Dogger Bank South Offshore Wind Farm

**Appendix E8 to the Natural England Deadline 8 Submission**  
**Natural England's comments and updated advice on Fish and Shellfish**

Planning Inspectorate Reference EN010125

4<sup>th</sup> July 2025

**Appendix B – Sandeel Habitat Potential in the Dogger Bank
SAC and Southern North Sea SAC**

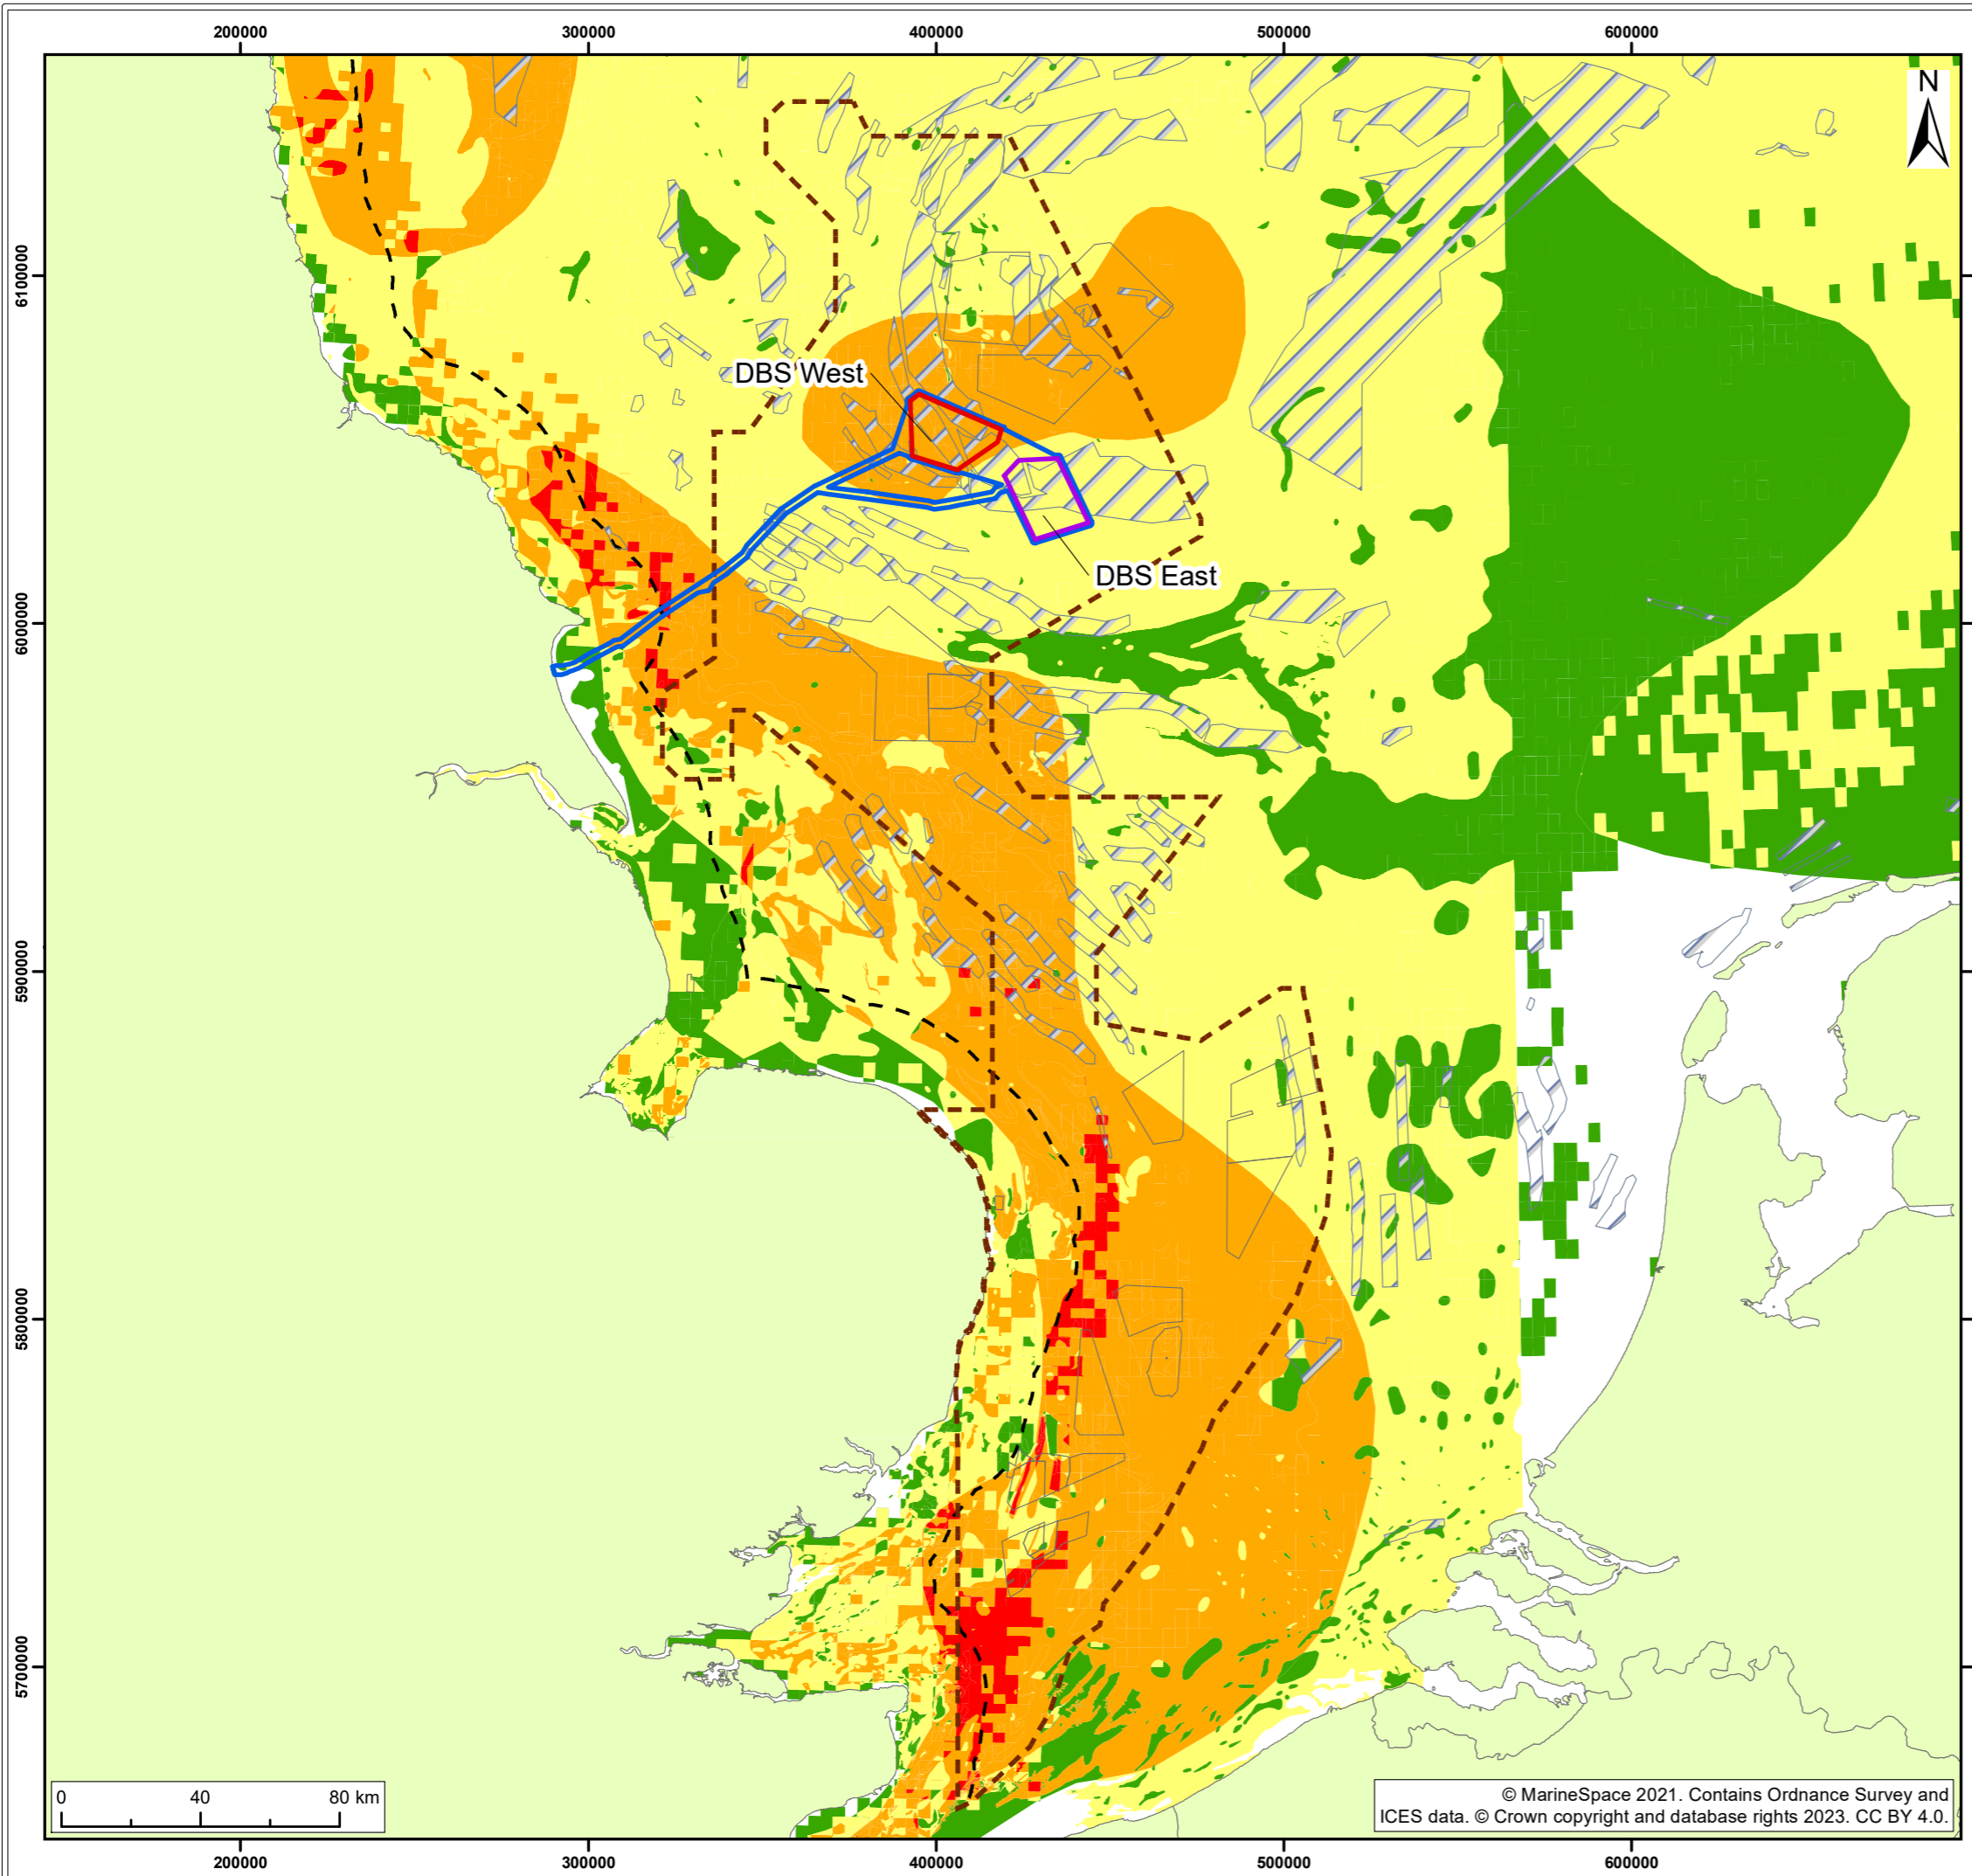
Whilst we welcome the Applicant's additional calculation of habitat loss resulting from ecological halo effects, UXO clearance and jack-up operations provided in the Updated RIAA HRA Part 2 of 4 [REP7-017], Natural England maintain our previous advice [REP5-056] that it would be beneficial for updated estimates to be provided including potential sandeel habitat loss from both existing and proposed developments (e.g. aggregates, oil and gas, cables and pipelines) occurring within the foraging ranges of affected designated predator species, or within Dogger Bank SAC and Southern North Sea SAC as a minimum. Whilst the Applicant lists potential developments to screen in for the final cumulative effects assessment (CEA) in ES Chapter 10 [REP7-043], they are not taken through to the screened in developments for further assessments due to operational projects (Tier 1 schemes) being considered part of the baseline for the CEA methodology. Whilst we acknowledge that this is usually the case, we highlight that this does not align with the approach taken by the Applicant to cumulative impacts caused by other offshore wind farms in Dogger Bank SAC and SNS SAC in 6.1.2 Appendix B - Sandeel Habitat Potential in the Dogger Bank SAC and Southern North Sea SAC [APP-050].

**'Without Prejudice' Herring Spawning Plan
(Revision 2)**

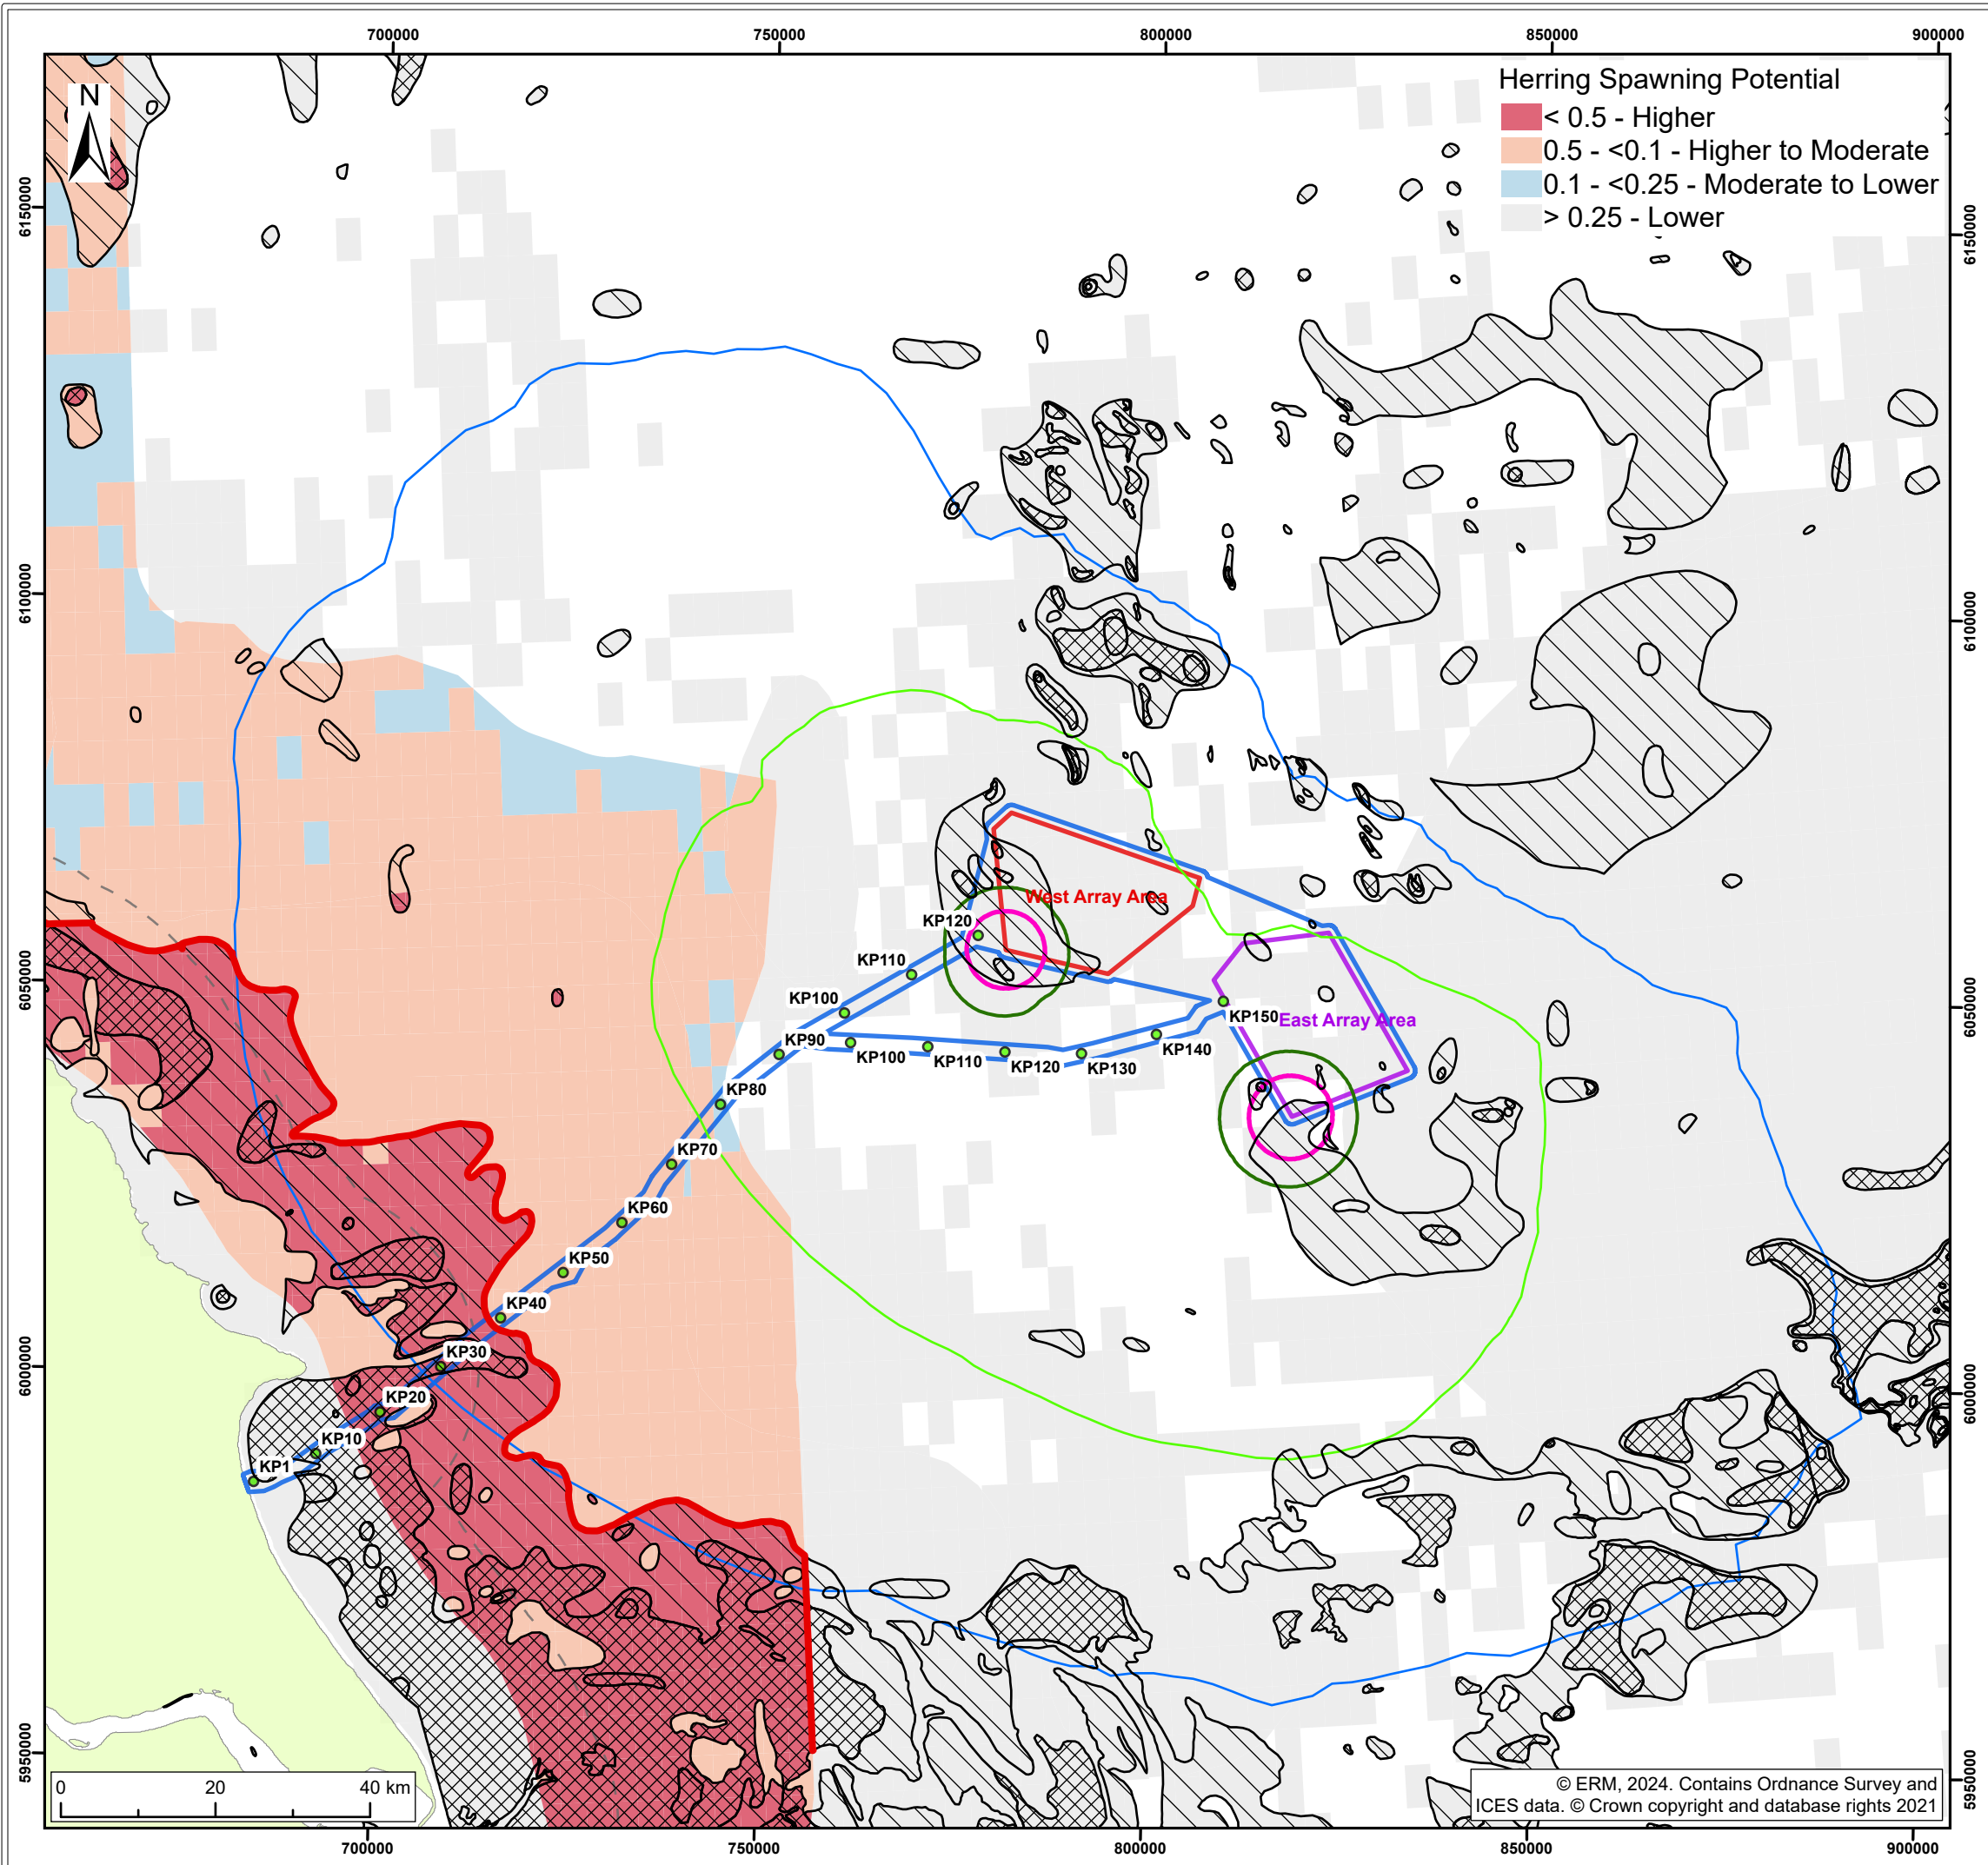
To note – we believe there may be an error in the restriction boundary line presented in the Herring Spawning Plan [REP7-135] where it does not align with the underlying marginal substrates boundary (Figure 1).

**Figure 1:** Section of Figure 17.8 taken from the Applicant's Herring Spawning Plan [REP7-135]. The black rectangle has been added by Natural England to highlight where the restriction boundary (red line) does not align with the underlying substrate boundary (black line).
